Re: Proposed Detached Dwelling with Integral Garage.

At: Land Adj. Gate Inn, Chapel Road, Pilley, Barnsley. S75 3AR

Application No: 2014 / 0330. Application Date: 24th. March 2014.

PROJECT	Detached Dwelling
CLIENT	Mr. Neil Anthony
TITLE	Elevations as Proposed
ADDRESS	Land adj. Gate Inn, Chapel Rd, Pilley, Barnsley. S75 3AR
DRAWN BY	ggg
SCALE	1:100
DATE	Mar 14
DRAWING No	751-19
REV	A
Member of the Chartered Institute of Architectural Technologists

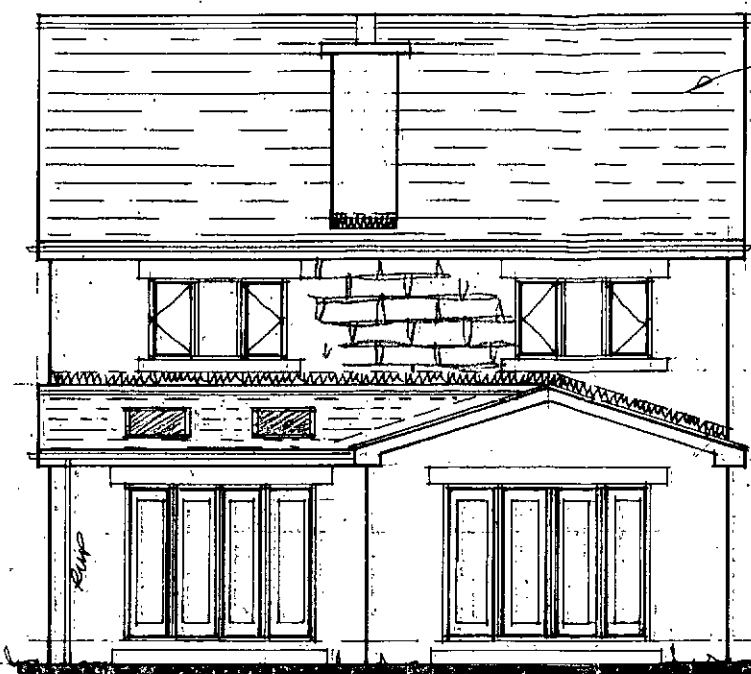
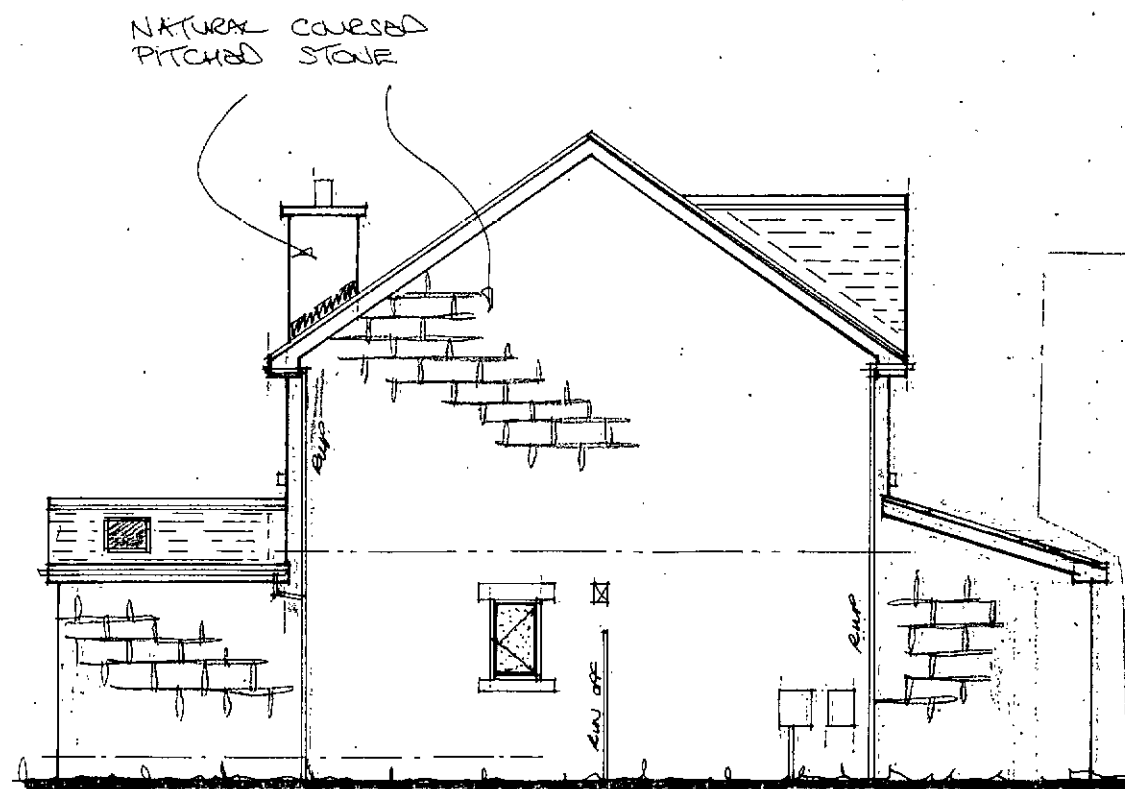
- i) the removal of the front Car Port construction;
- ii) the alterations to the Integral Garage to satisfy Highways requirements.
